CITY OF PORTLAND
 FIRE PREVENTION BUREAU
 380 Congress Street, Portland, Maine 04101
 fireprevention@portlandmaine.gov
 (207) 874-8400

NOTICE OF VIOLATION AND ORDER TO CORRECT

Responsible Party 1: Doering Ralph 18 MT VERNON ST #1 BOSTON, MA 02108		Responsible Party I: PETER ADAMS 215 STATE ST PORTLAND, ME 04101
Location 111 STATE ST	CBL 045 B029001	Inspection Date 4/3/2017
Inspector Dean Berry	Inspection Type FP Routine Inspection	Status Failed

PROTECTION PROFESSIONALS  
DATE 11/17/17  
REVISION: 1.0  
111 STATE STREET  
PORTLAND MAINE  
SCALE: NS  
SHEET: 1 1ST FLOOR  
DESIGNER:  
DOUG HANSEN

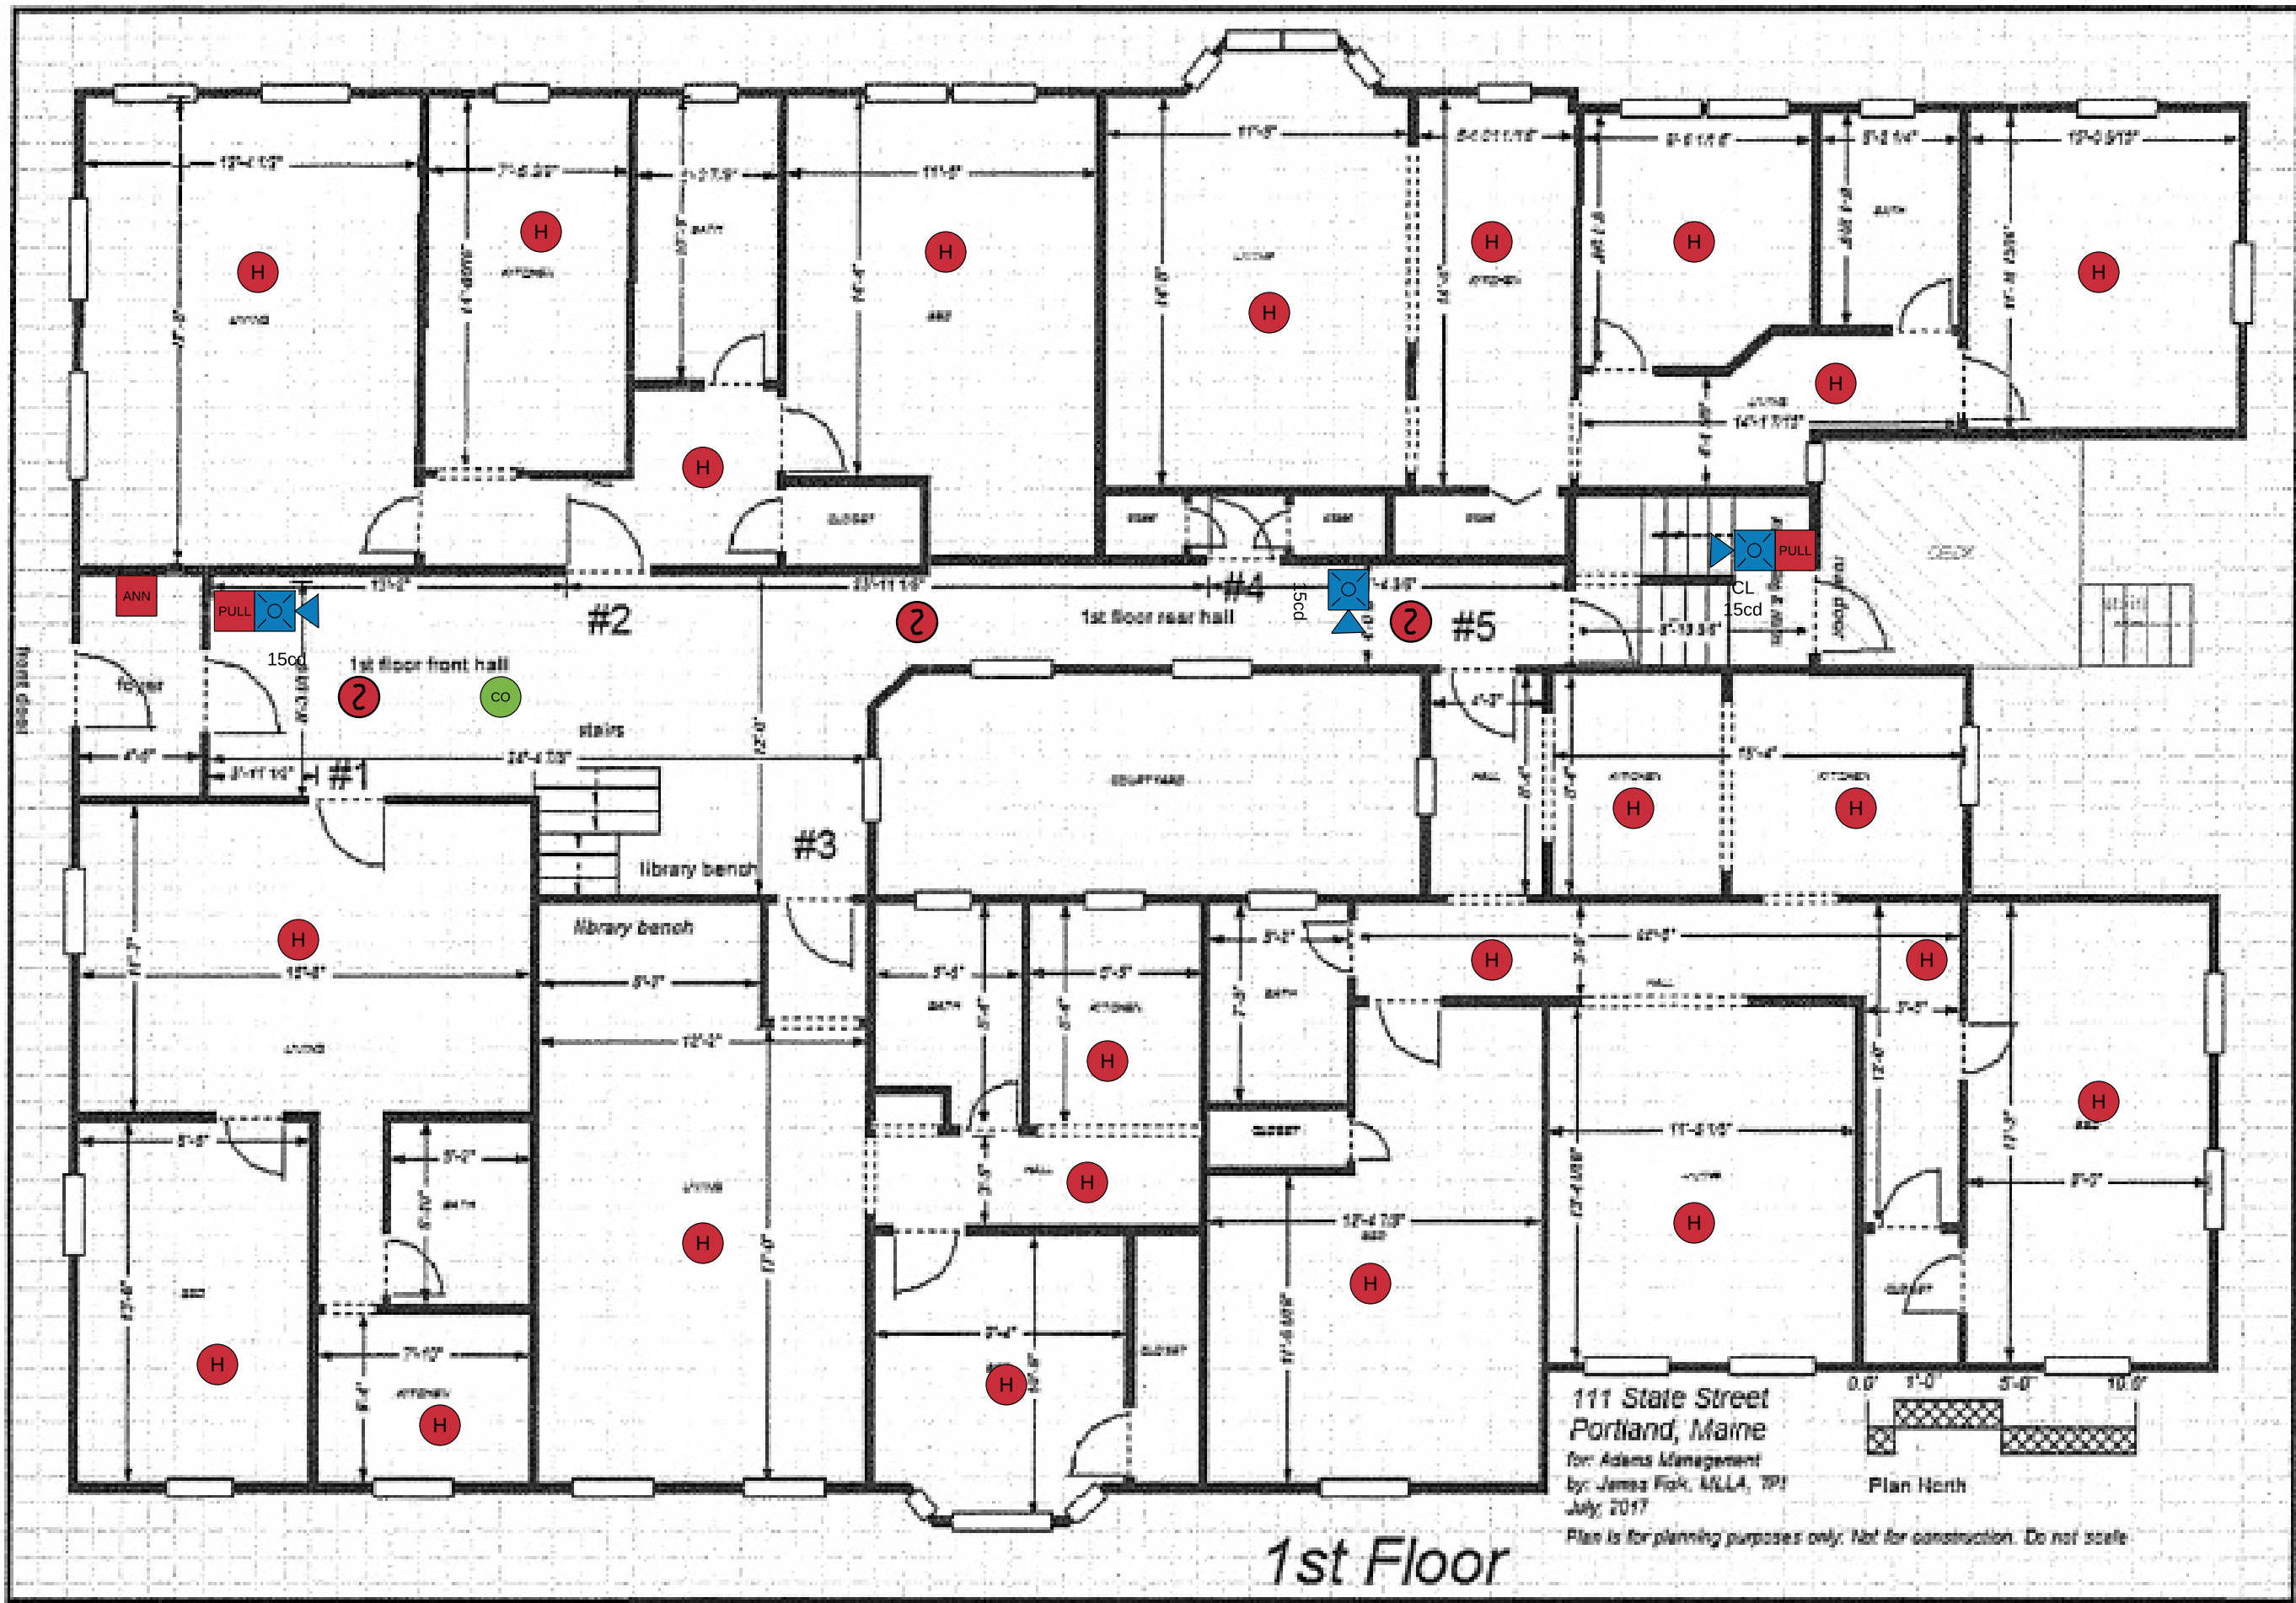
Violation	Proposed Date of Completion
NFPA 101- 31.3.4.1.1 FIRE ALARM SYSTEM<11 UNITS OR ><3 STORIES> ; Apartment buildings four or more stories in height or with more than 11 dwelling units, other than those meeting the requirements of 31.3.4.1.2, shall be provided with a fire alarm system in accordance with Section 9.6, except as modified by 31.3.4.2 through 31.3.4.6. Building Rep said the owners are aware and working on it.	
NFPA 101- 31.2.9 EMERGENCY LIGHTS REQUIRED; Emergency lighting in accordance with section 7.9 shall be provided in all buildings four or more stories in height or with more than 12 dwelling units, unless every dwelling unit has a direct exit to the outside of the building at grade level.	
NFPA 101- 7.2.1.8.1 DOORS SHALL BE SELF-CLOSING & SELF-LATCHING; A door leaf normally required to be kept closed shall not be secured in the open position at any time and shall be self-closing or automatic-closing in accordance with 7.2.1.8.2, unless otherwise specified by 7.2.1.8.3. Several of the old style fire doors do not close fully and none latch. Include the rear staircase and Boiler room doors.
